**Atlassian Office and Hotel Development (SSD-10405) - Notice of Exhibition**

Thank you for your correspondence via the Major Projects Portal on 10 December 2020, requesting Transport for NSW (TfNSW) to review and comment on the above.

## **Attachment A: Items to be addressed as part of the Response to Submissions (RtS)**

DRAWING	
DIVE RAMP SECTION	
DOCUMENT NUMBER	ISSUE
DA-11D-XXX-02	7

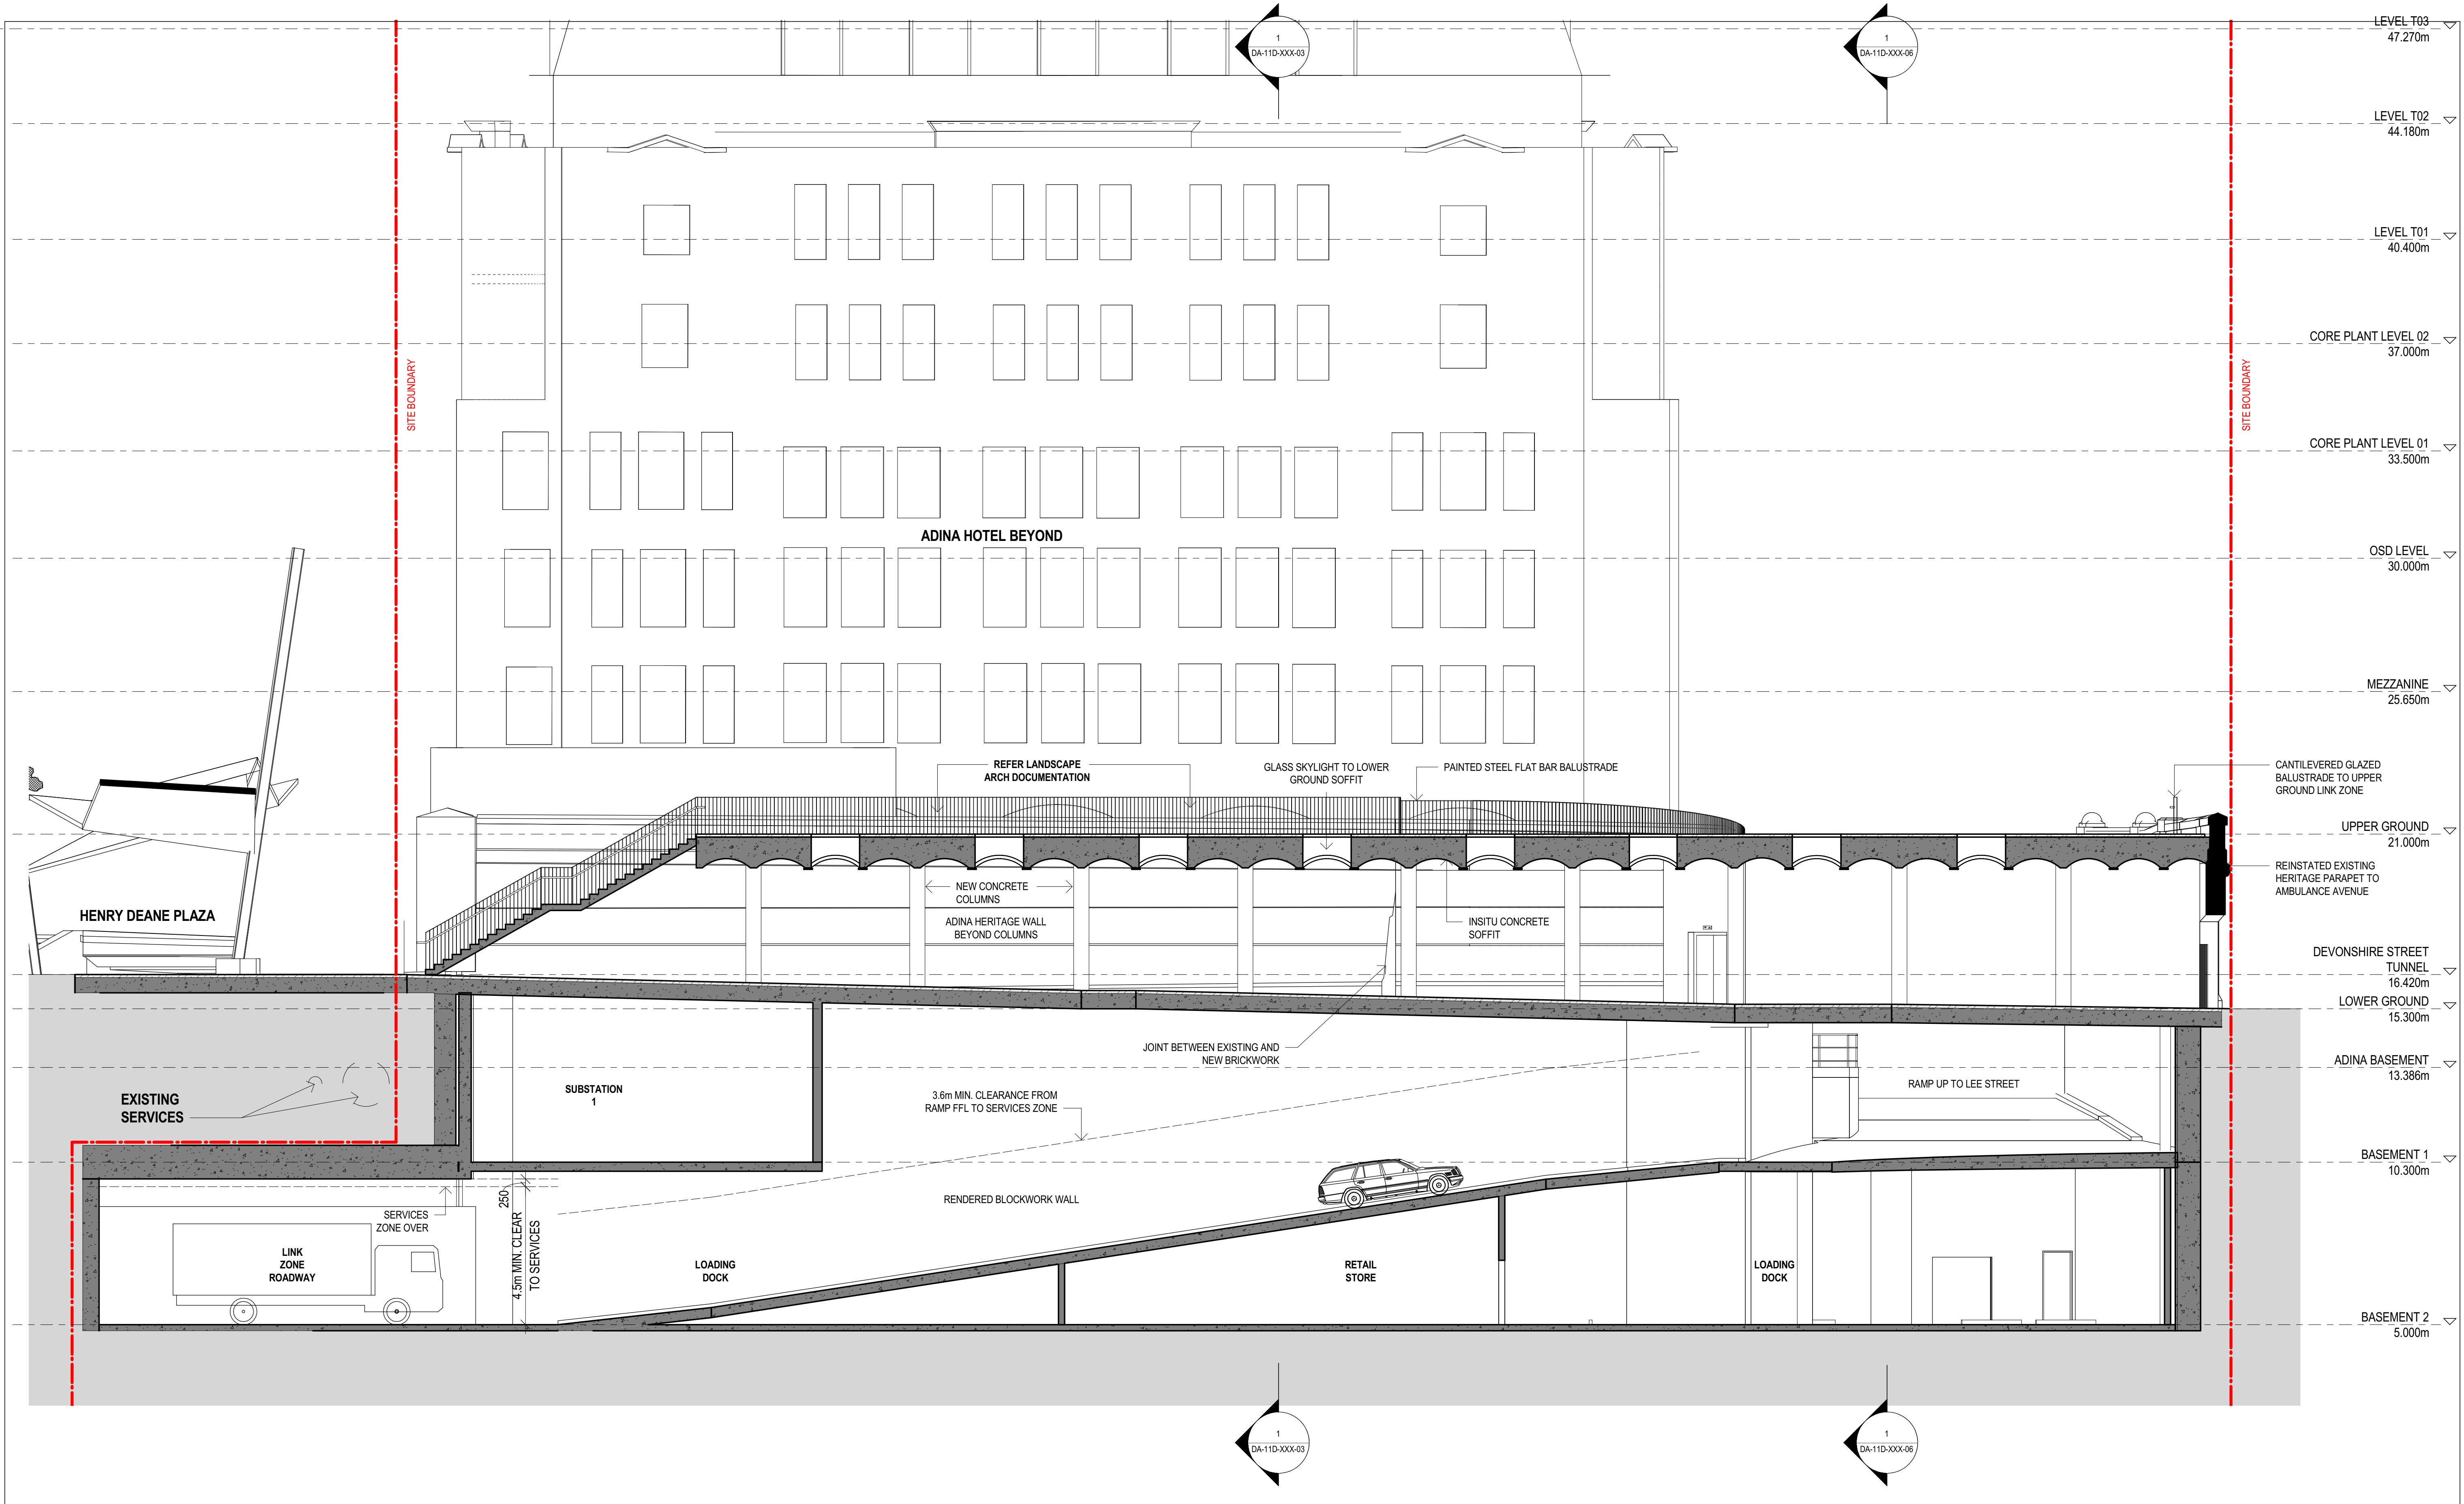
- Undertake a Swept Path analysis for the maximum size of the vehicle that would expect to use the loading dock to demonstrate that:
  - Simultaneous service vehicle movements to/from Lee Street through dive ramp structure would be possible as the proposed access arrangement would have the potential to lead vehicles to reverse into Lee Street and give way to the vehicles leaving the site and causing pedestrian and traffic related incidents; and

- The management of conflicts on the B2 ramp has been detailed in Section 4.5 of the Traffic Report, however, no arrangements are proposed to manage conflicts beyond this point at the Lee Street access. That is, a service vehicle about to depart onto Lee Street would prevent a vehicle entering given the driveway width of 5.5 m does not allow simultaneous movement. Importantly, this has the potential to impact the nearby Lee Street / Pitt Street / George Street intersection;

- A Stage 2 (Concept Plan) Road Safety Audit for the proposed Lee Street access arrangement, Lee Street pick and drop off arrangement and the access arrangement between the loading dock and Lee Street in accordance with *Austroads Guide to Road Safety Part 6: Managing Road Safety Audits* and *Austroads Guide to Road Safety Part 6A: Implementing Road Safety Audits* by an independent TfNSW accredited road safety auditor; and
- A Swept Path analysis for the simultaneous service vehicle movements to/from Lee Street through dive ramp structure for the maximum size of the vehicle that would expect to use the loading dock. Swept paths need to cover the vehicle travel paths between Lee Street and the loading dock.

- Traffic and pedestrian safety assessment including historic crash analysis to confirm that the proposed measures along Lee Street would not exacerbate existing safety issues; and
- An assessment of conflicts at the Lee Street access to provide mitigation measures to minimise the impacts on Lee Street / Pitt Street / George Street intersection and Lee Street.
